Gatwick Airport Northern Runway Project

Examination Ref: TR020005

Supporting Noise and Vibration Technical Notes to the Statements of Common Ground - Book 10 – Version 1- April 2024 – Document reference 10.13 [REP3-071] Review

Deadline 4: 15 May 2024

Diagram 1: PEIR Noise Model (Scenario 1)

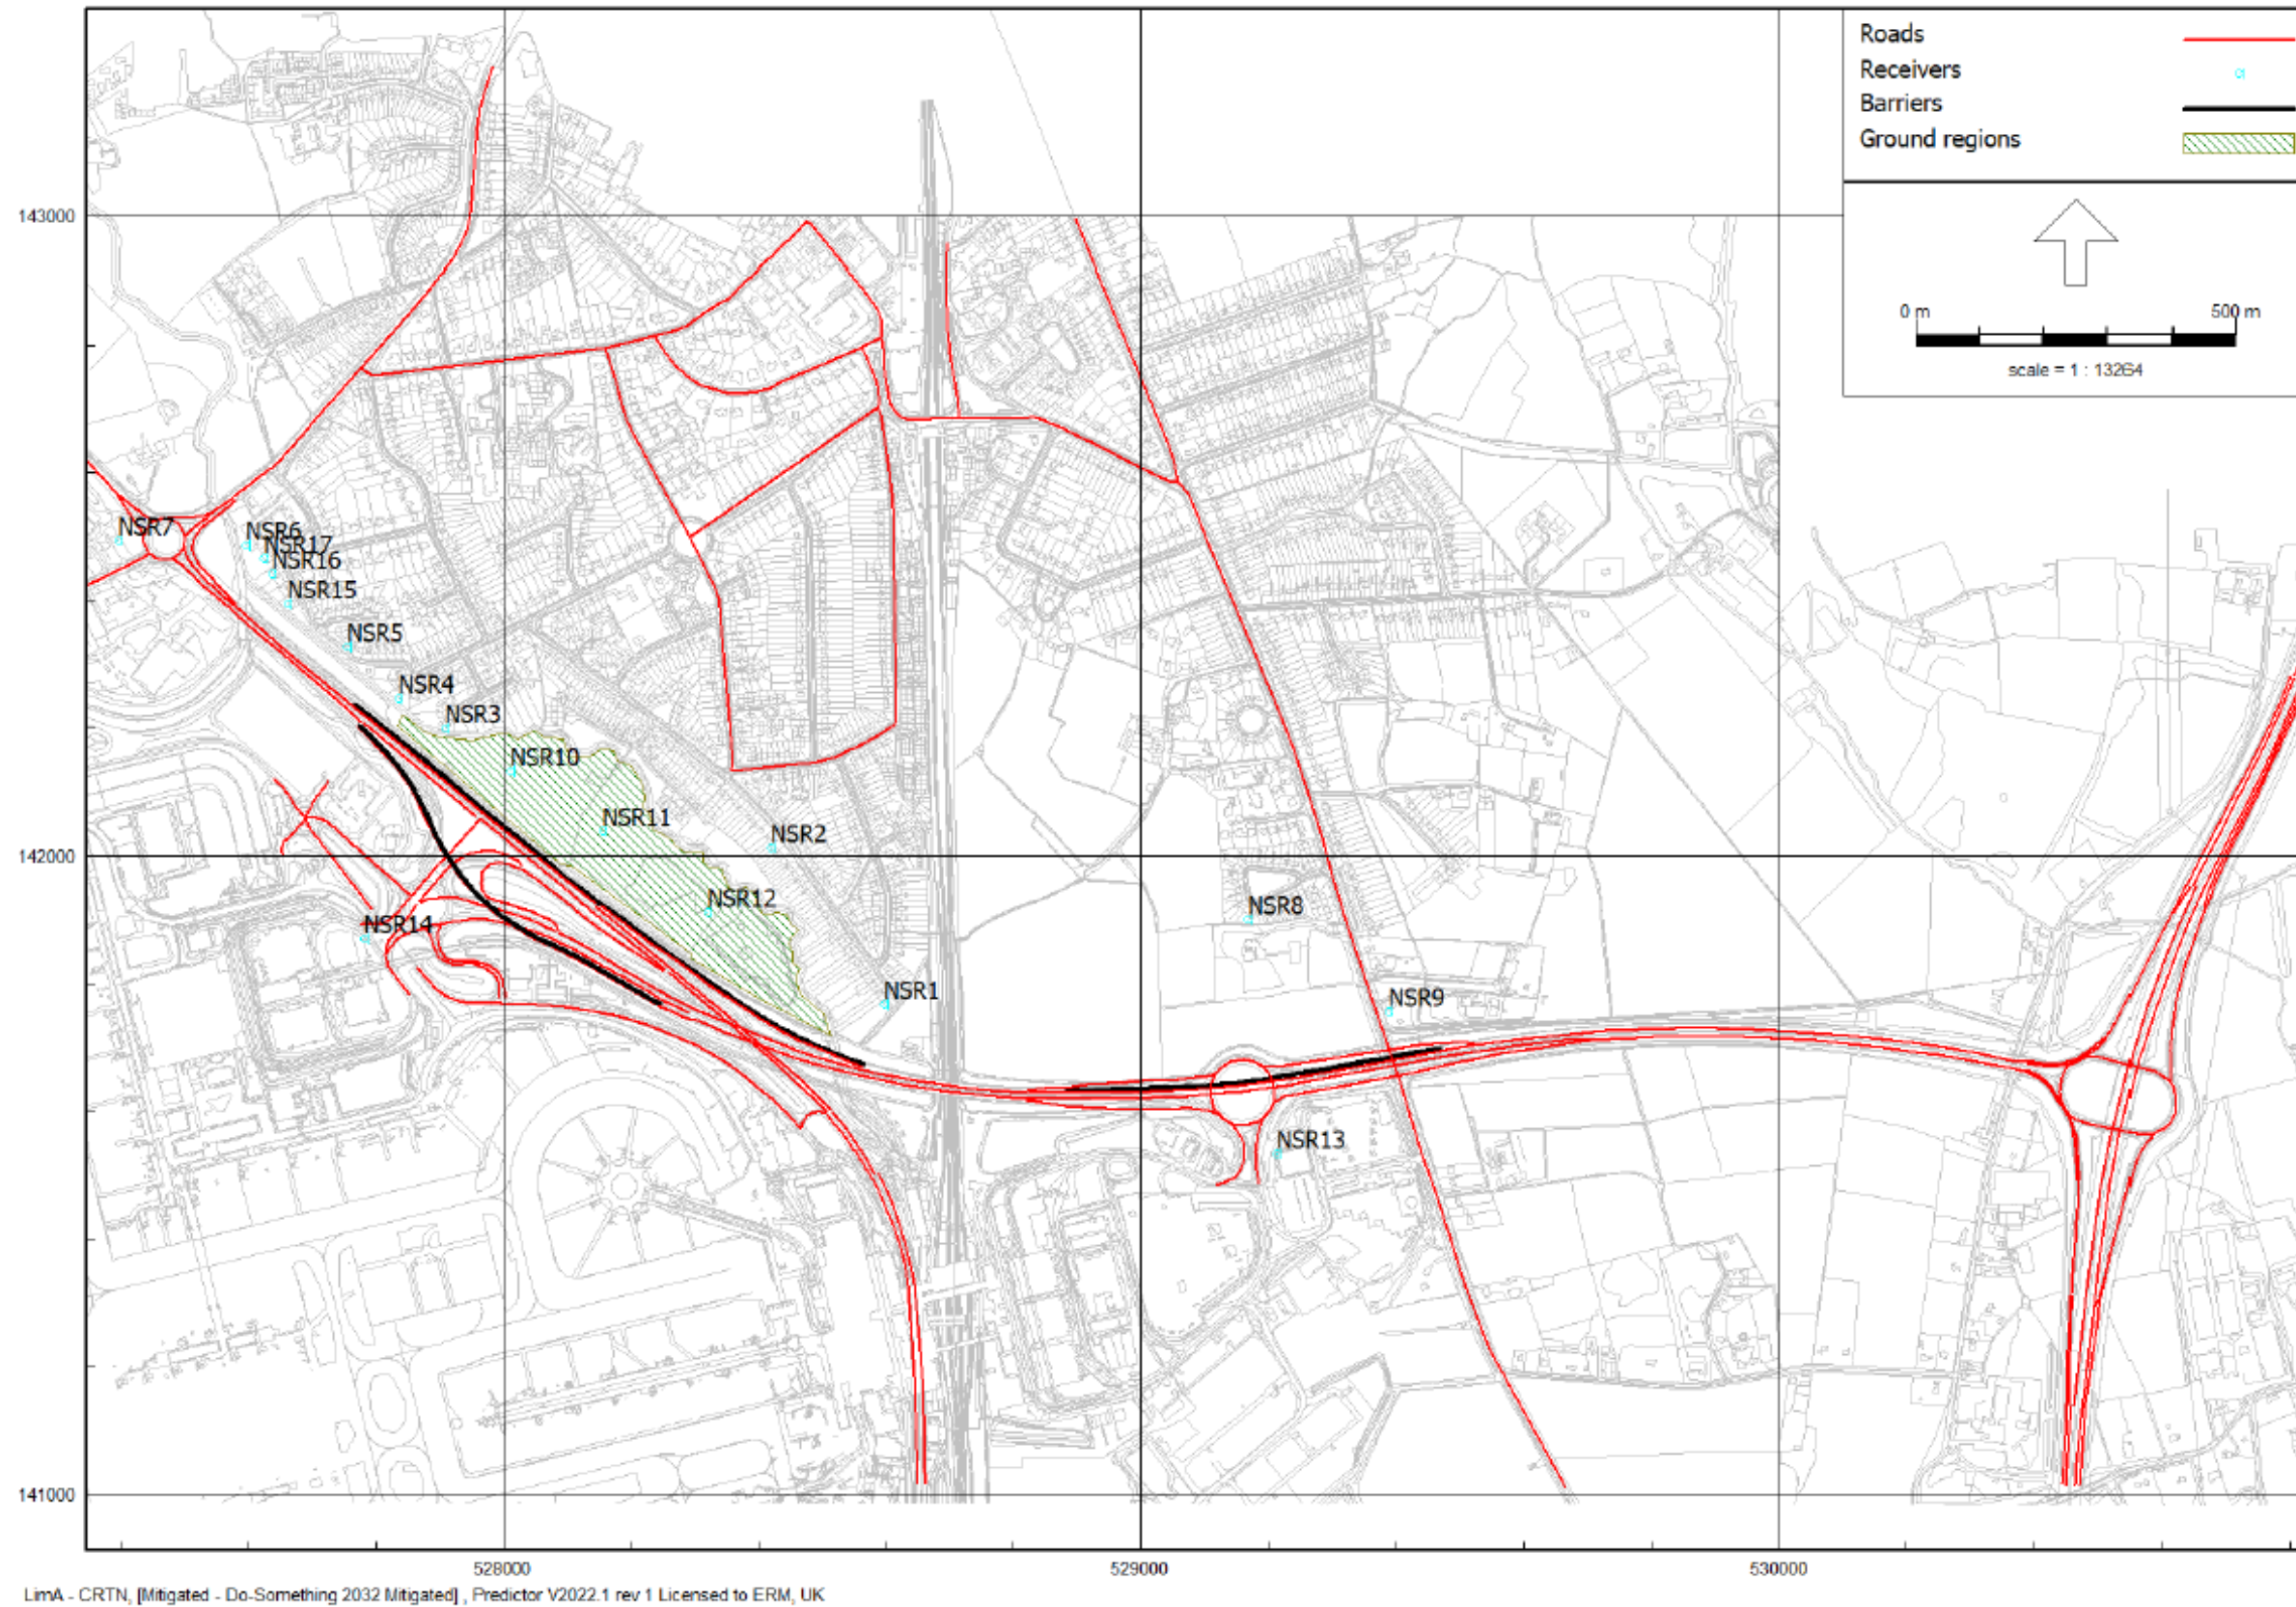
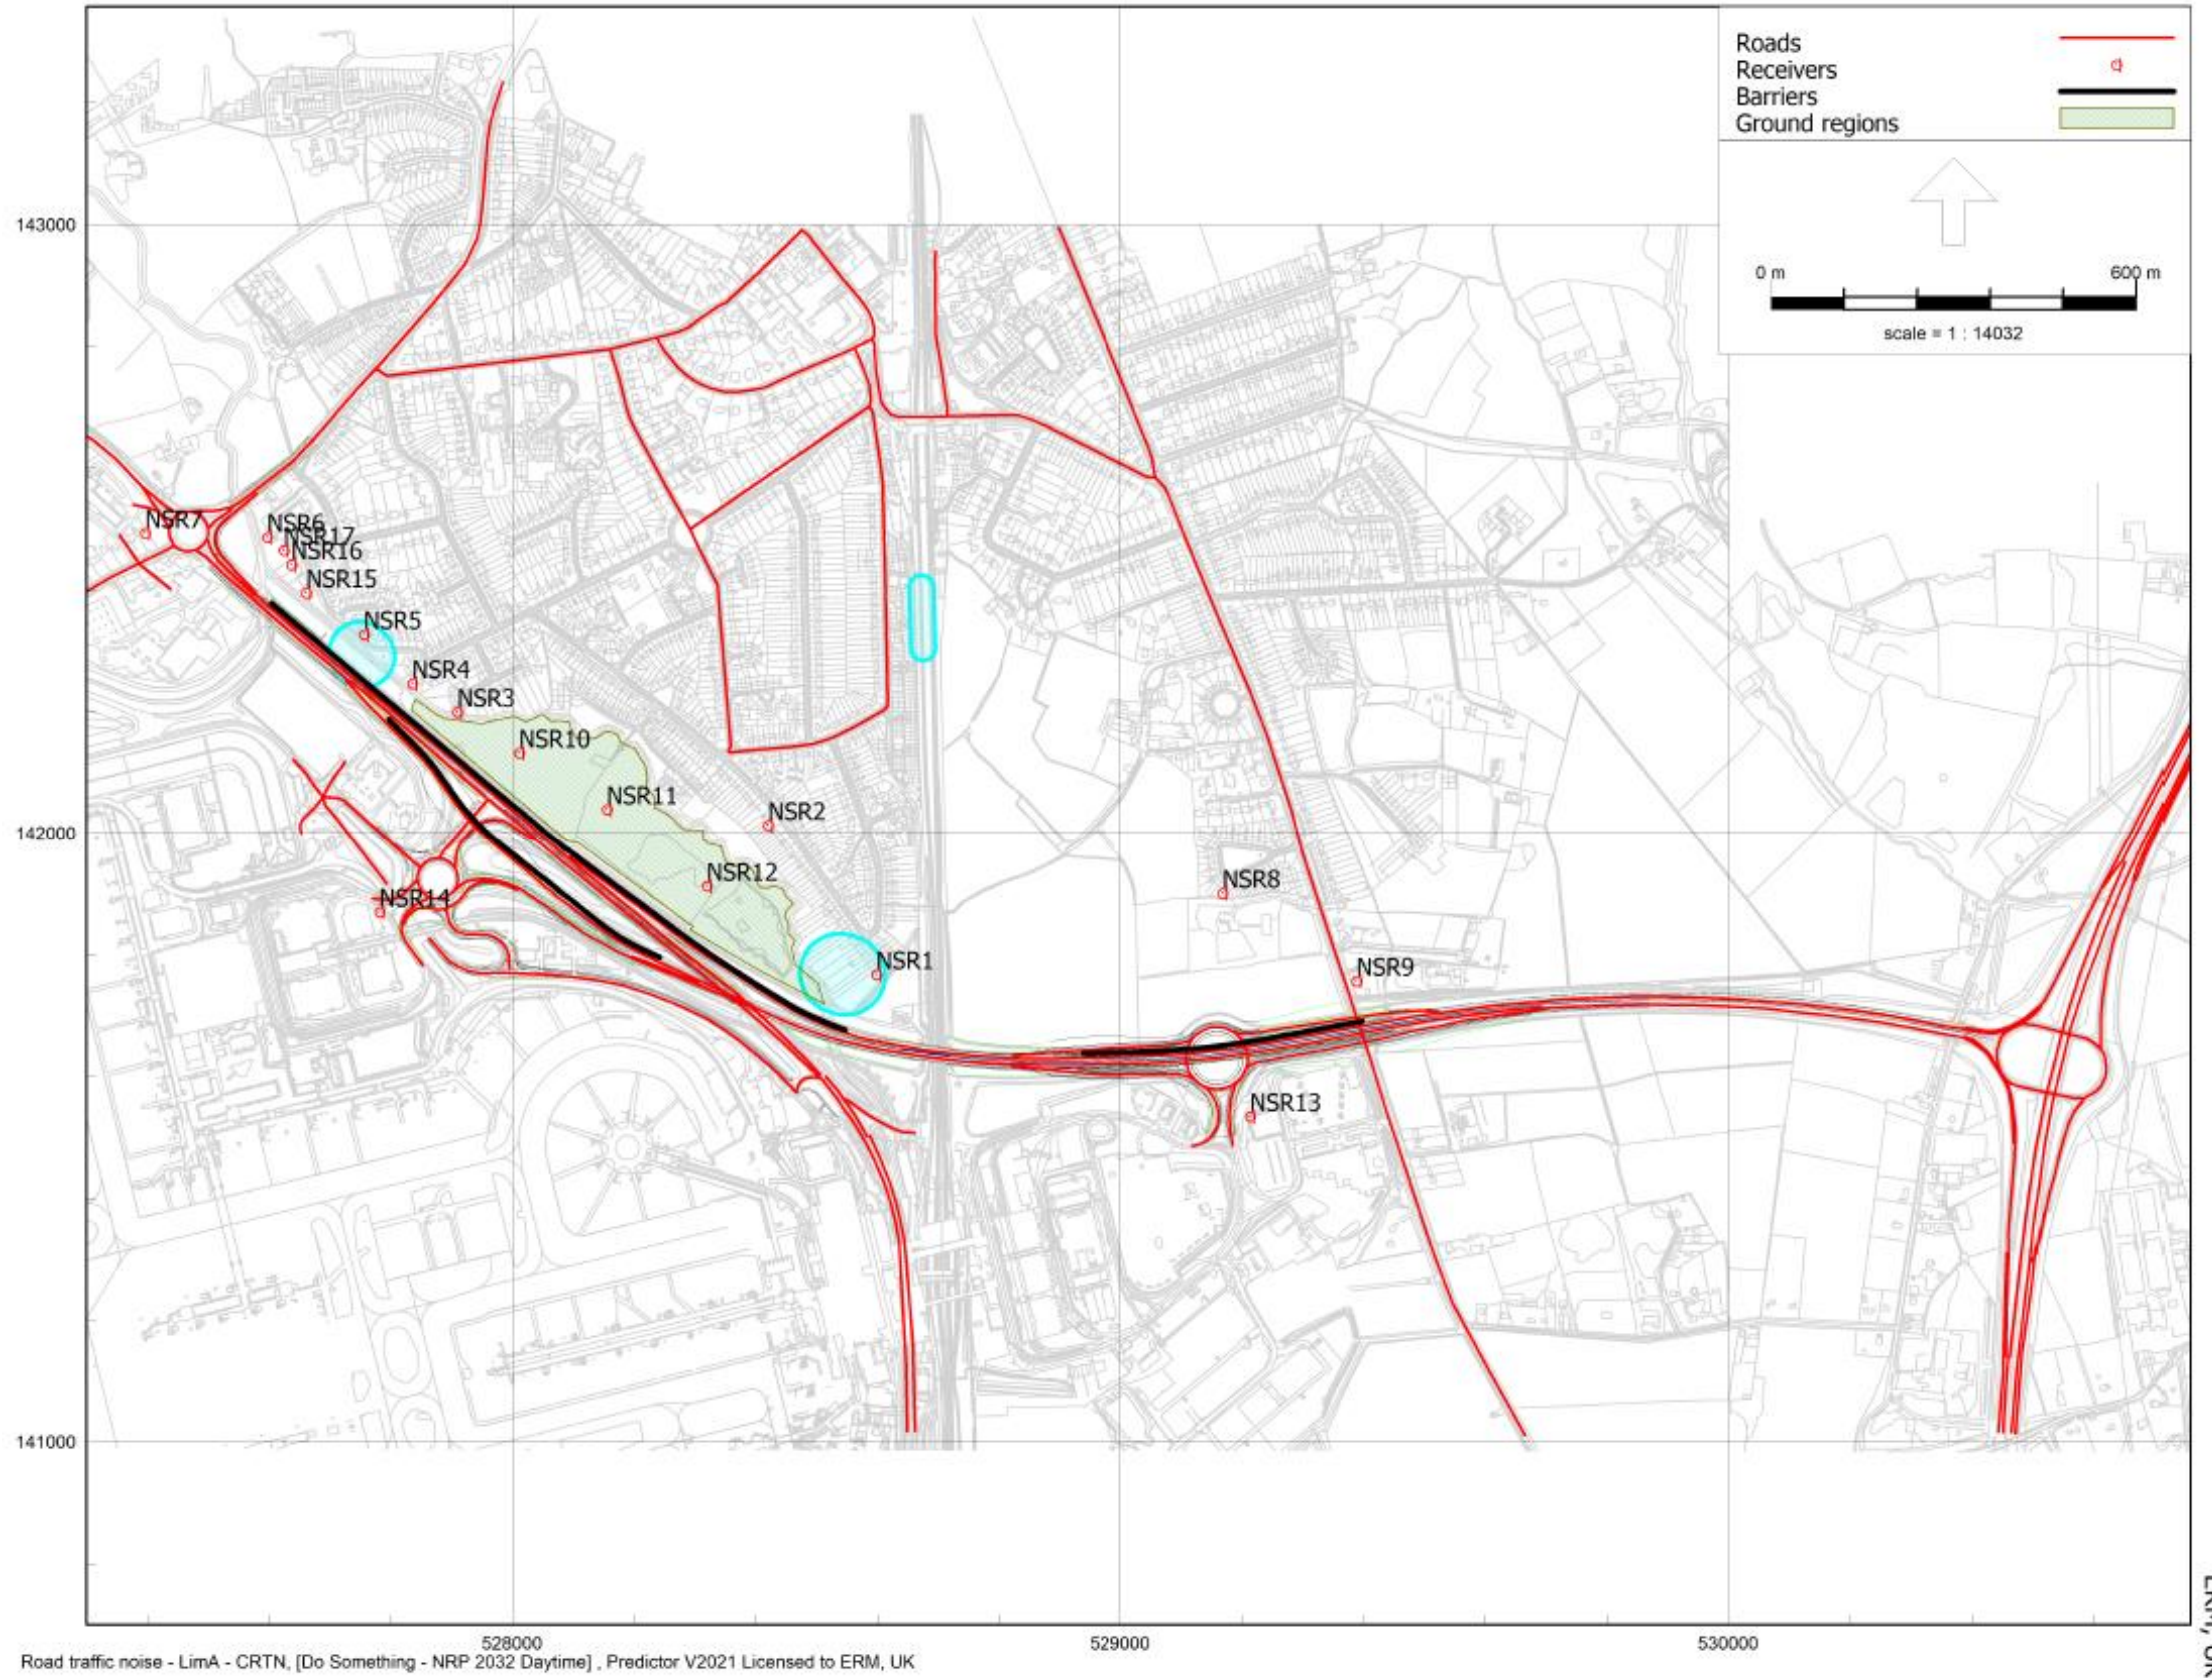
JLA-NVTN-C3	Table 2	Traffic noise predictions	A review of the traffic noise predictions was undertaken and the JLAs noted that the predicted ES road traffic noise levels in Table 2 did not match the ES predictions from Table 6.3.1 of ES Appendix 14.9.4 [APP-174] . They do match the results of the road traffic noise mitigation analysis in Table 5.1.1 of ES Appendix 14.9.4 [APP-174] . The JLAs would like to query why the results of Table 5.1.1 and Table 6.3.1 are different for baseline scenarios with specific focus on the 2018 baseline, which should be unaffected by traffic forecasts and mitigation.
Appendix D – Traffic Noise Important Area Assessment			
JLA-NVTN-D1	4.1.2	2032 is the most stringent assessment	Can the Applicant explain why 2032 is considered as the most stringent assessment for road traffic noise when, for similar projects, the worst-case assessment tends to be when aircraft movements are at their maximum
